**Section 96A of the Town & Country Planning Act 1990 (as amended)
Town and Country Planning (Development Management Procedure) (England) Order 2015 (as amended) - Article 10**

Application for a Non-Material Amendment Following a Grant of Planning Permission

Development: The key areas for change are to reduce the structure in size by approximately 2 sq.m, build the structure using a highly insulated timber frame construction rather than brick and block and replace the large single roof lantern with two, much smaller panoroof low level skylights.

Location: Carpenters Cottage Hoe Lane Flansham PO22 8NW

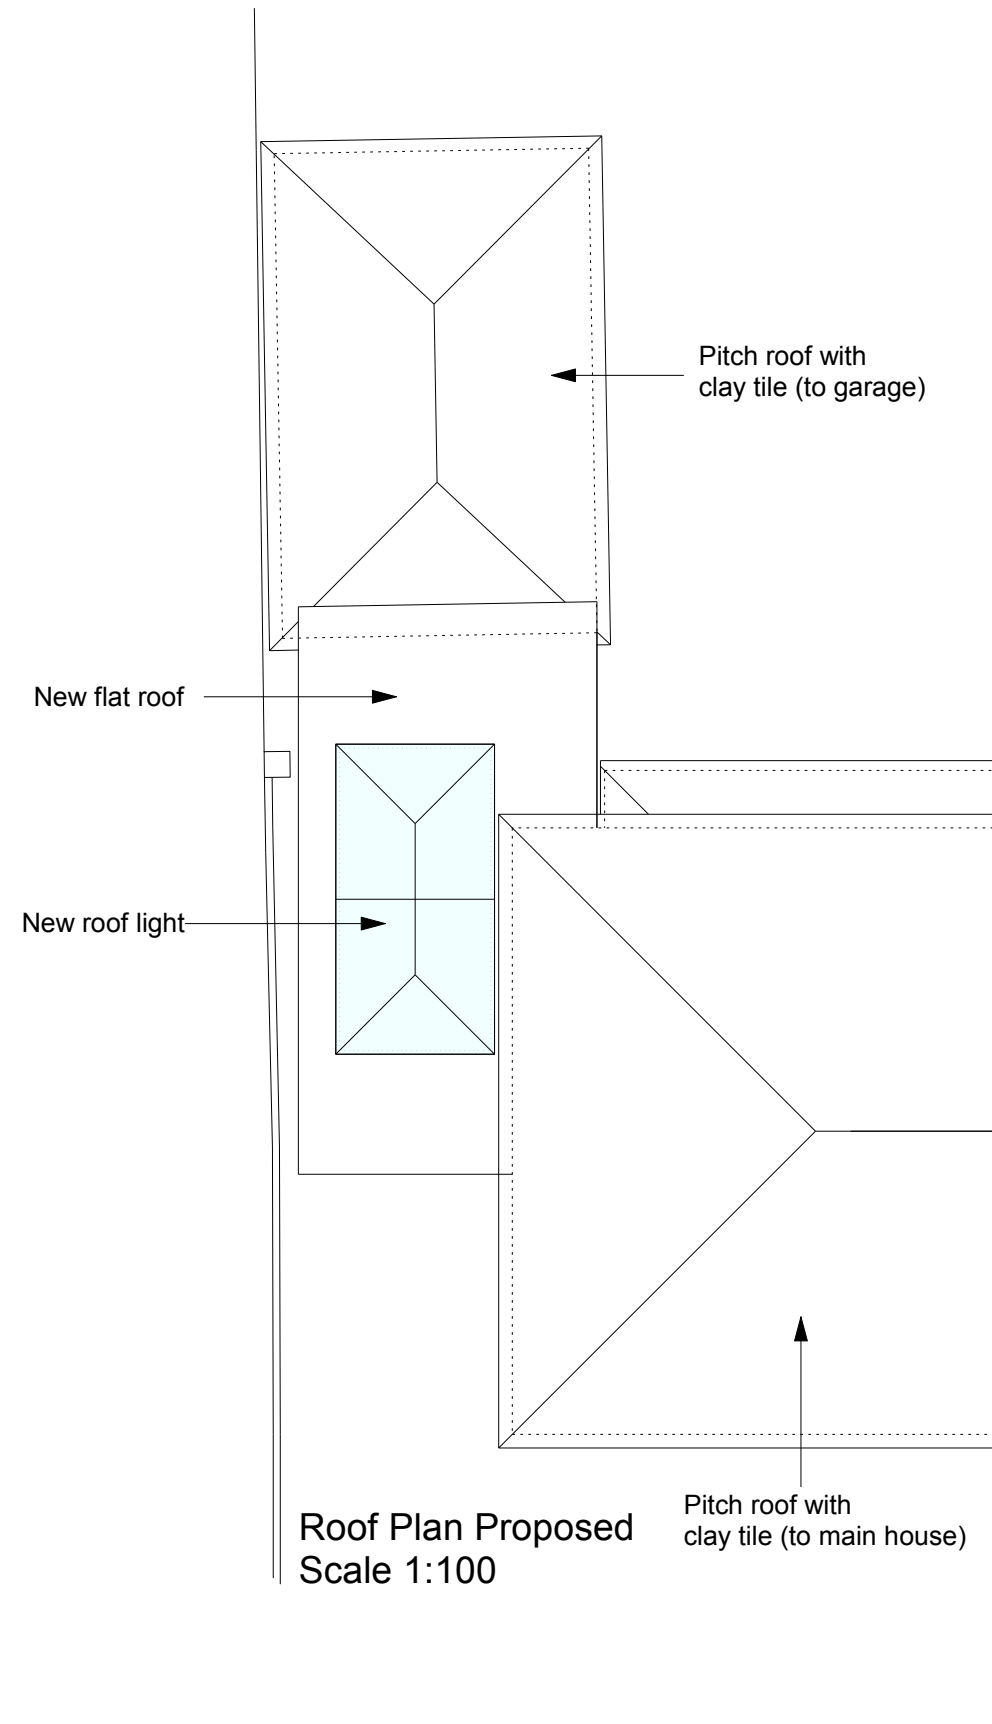
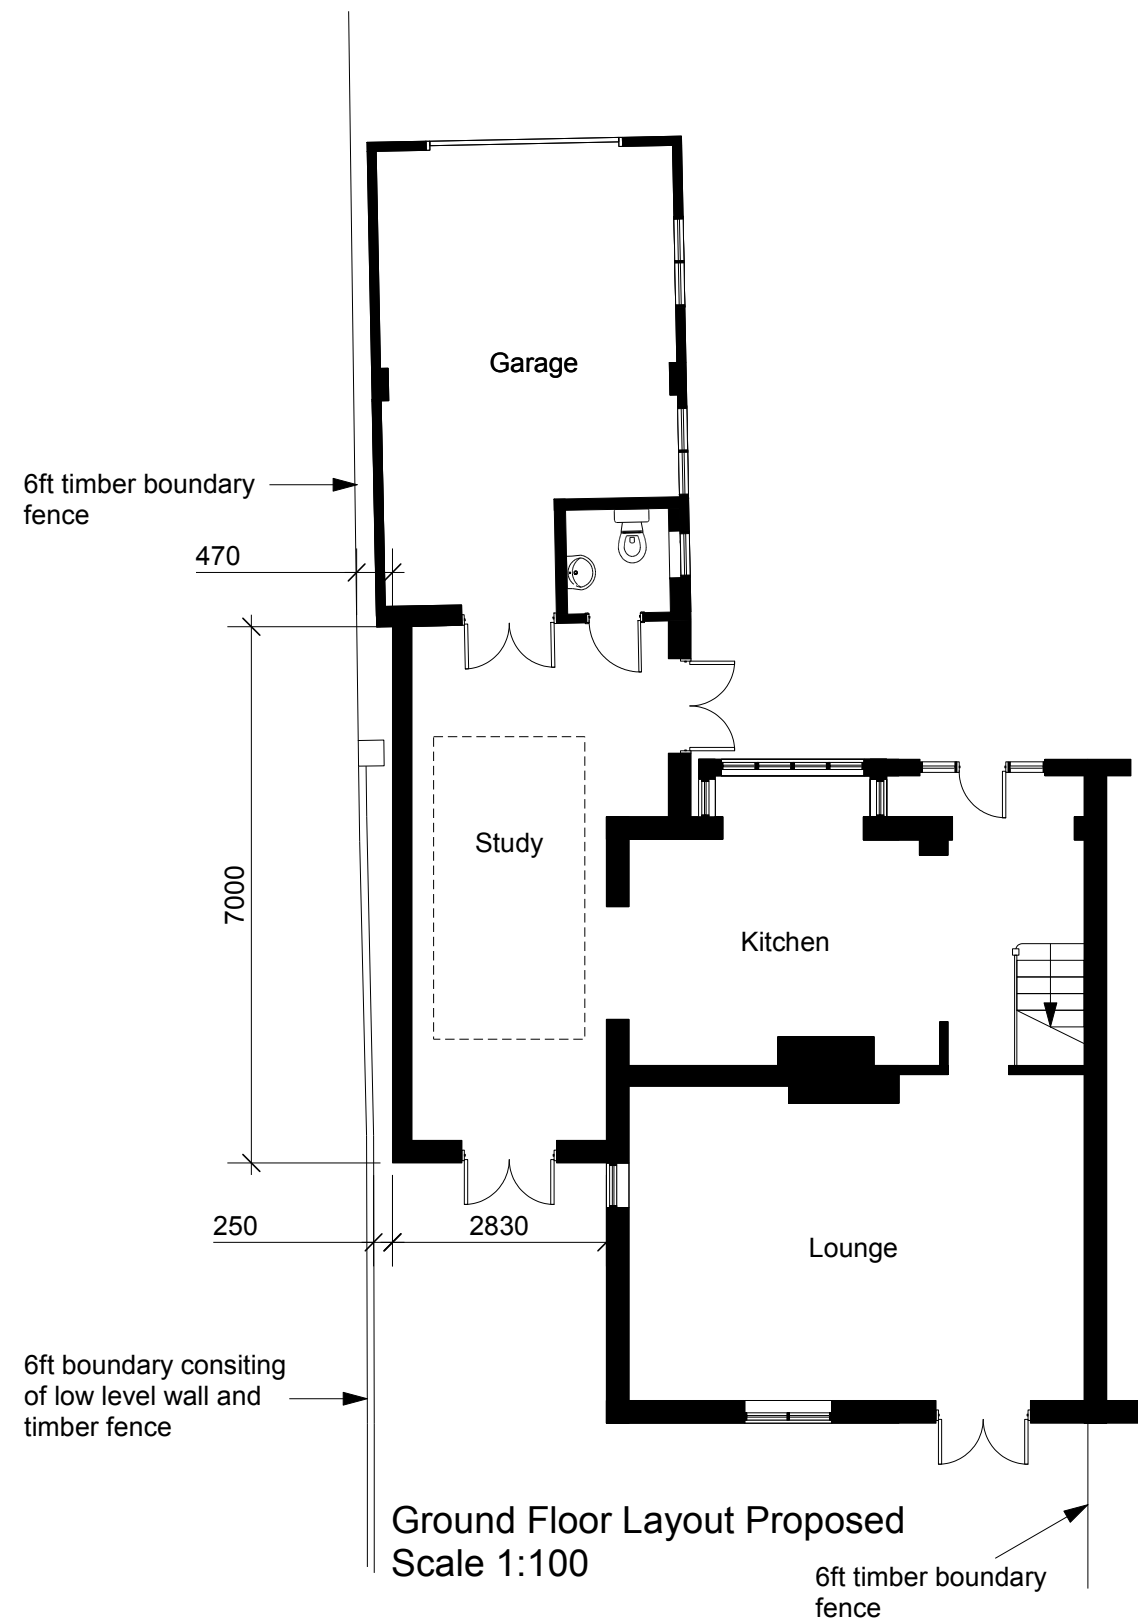
Dwg No CM005 is not to scale. Please re submit as a PDF ensuring Page Size and Sheet Size are set to Auto.

Proposed Ground Floor Plan Dwg No CM005 shows a bi-fold door on the rear elevation, however on the Proposed Rear Elevation Dwg No OM004 shows 2 patio doors and 1 window. Please check the plans and re submit the plans required for this application.
